City of Ryde Submission

15-21 Cottonwood Crescent, Macquarie Park
SSD-940006708

Council File reference: COR2025/484/6
Submission Date: 21 April 2026

SURVEYED BY	DRAWN BY	CHECKED BY	APPROVED BY
SURVEY INSTRUCTIONS 22451		SCALE 1"=200'	DATE OF SURVEY 15 JUL 2003
DRAWING NAME 22451detail		SHEET 6 OF 10	
CAD FILE 22451detail.dwg

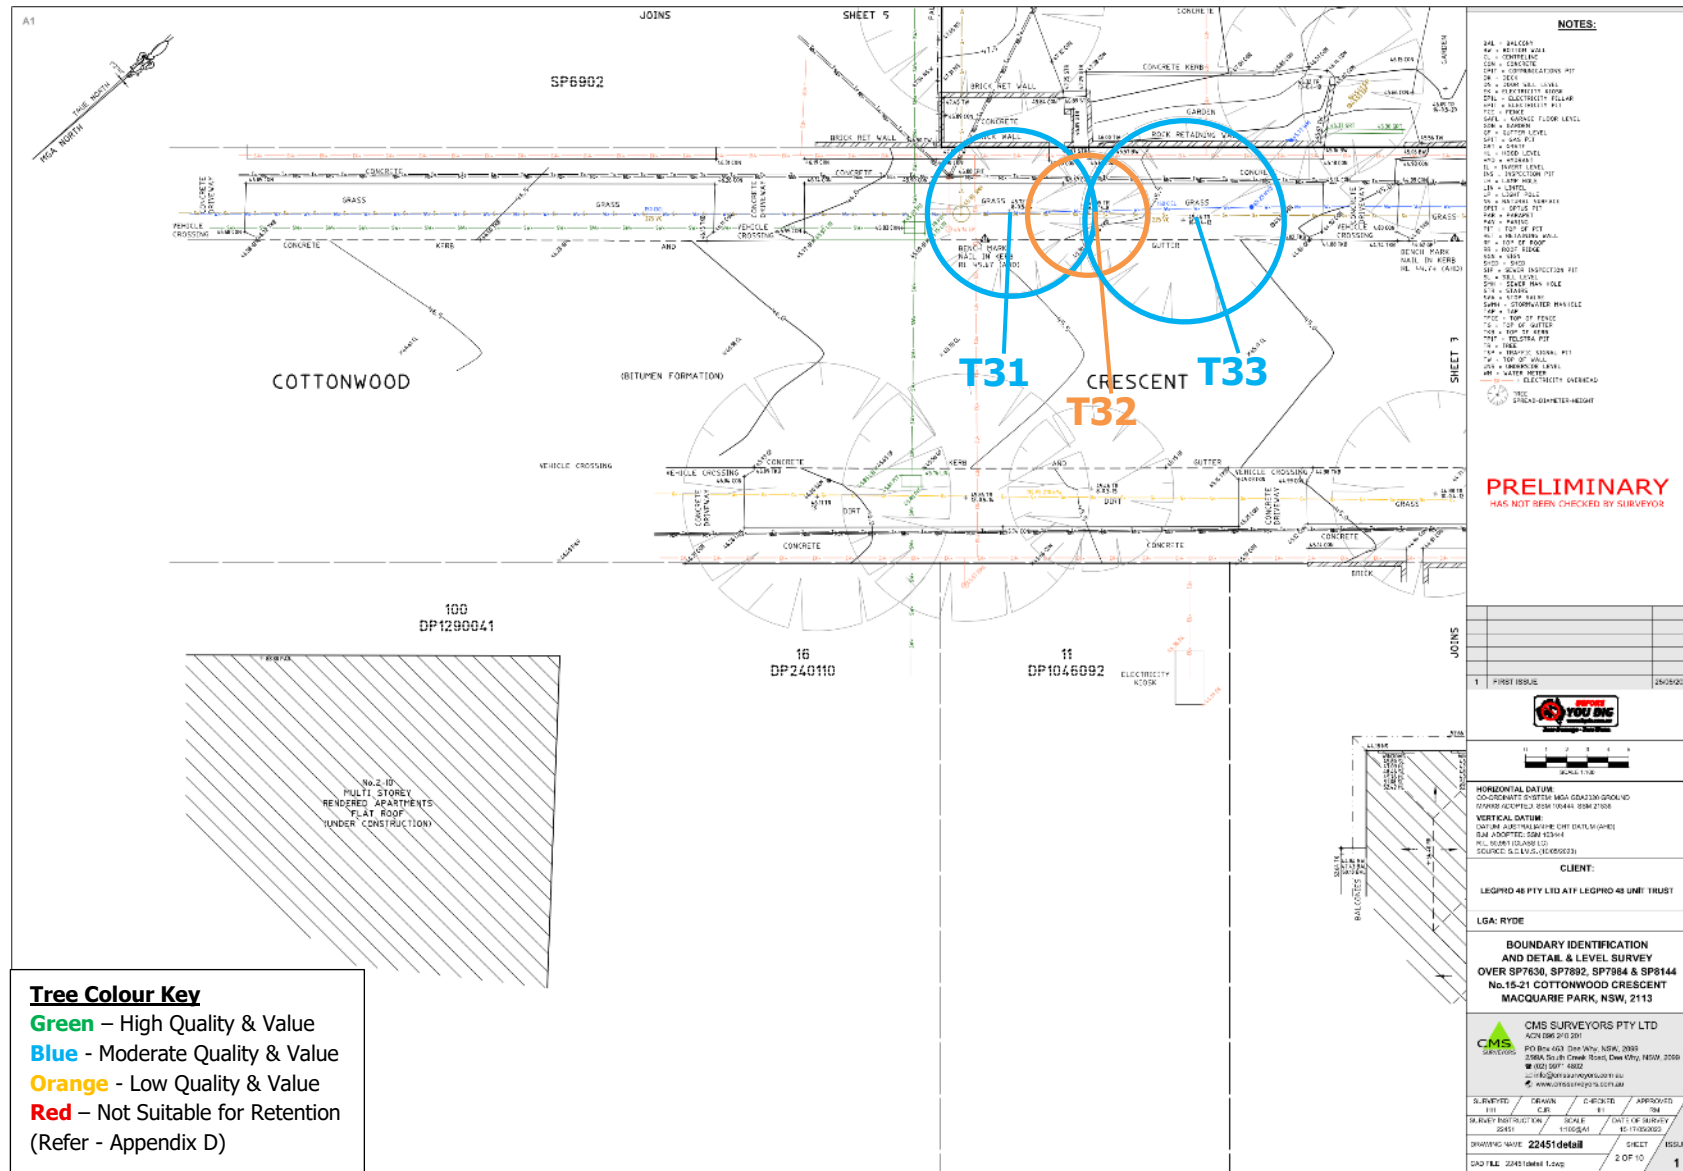
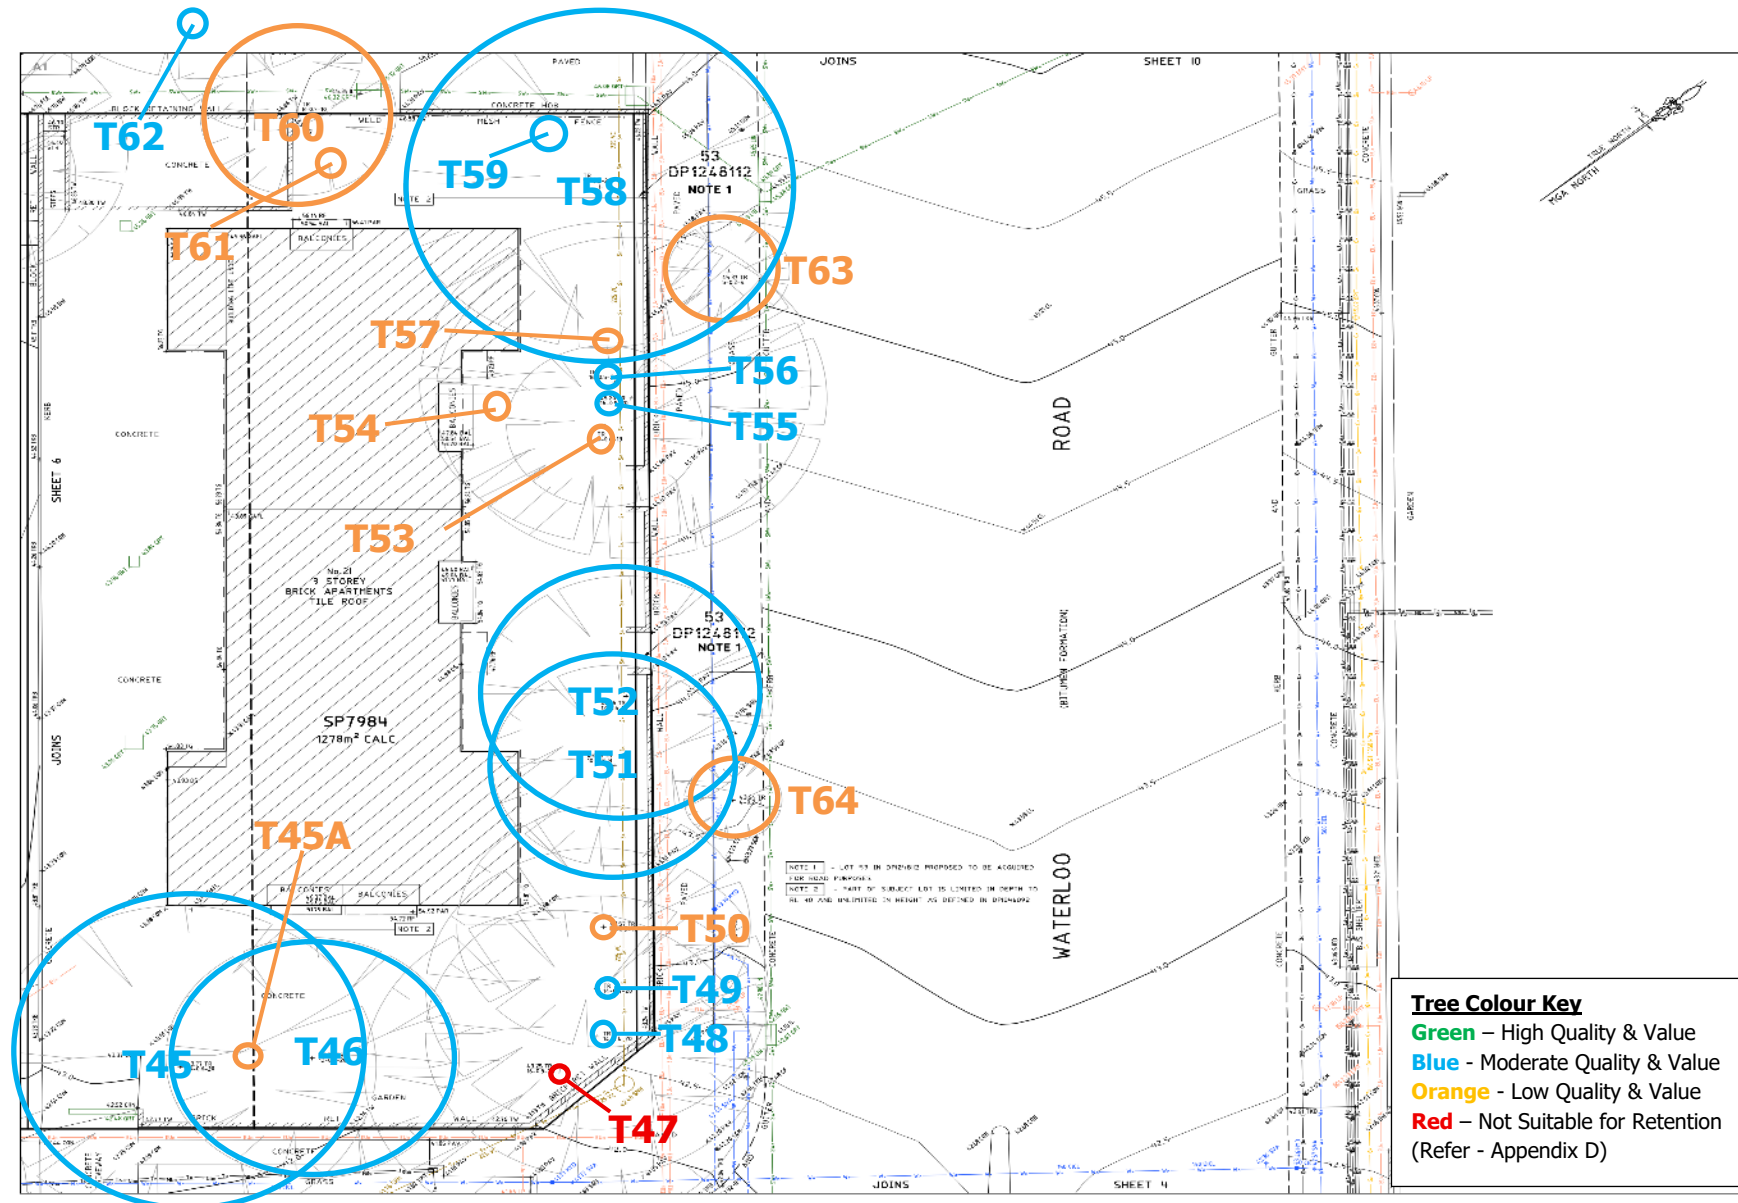
Existing mature trees along site boundaries currently provide shade and environmental value. The provided tree removal and retention plan indicates that most trees will be removed. All mature trees should be retained to the street edge at both Cottonwood Crescent and Waterloo Rd. Council requires a detailed arborist report for the removal of any existing mature trees.
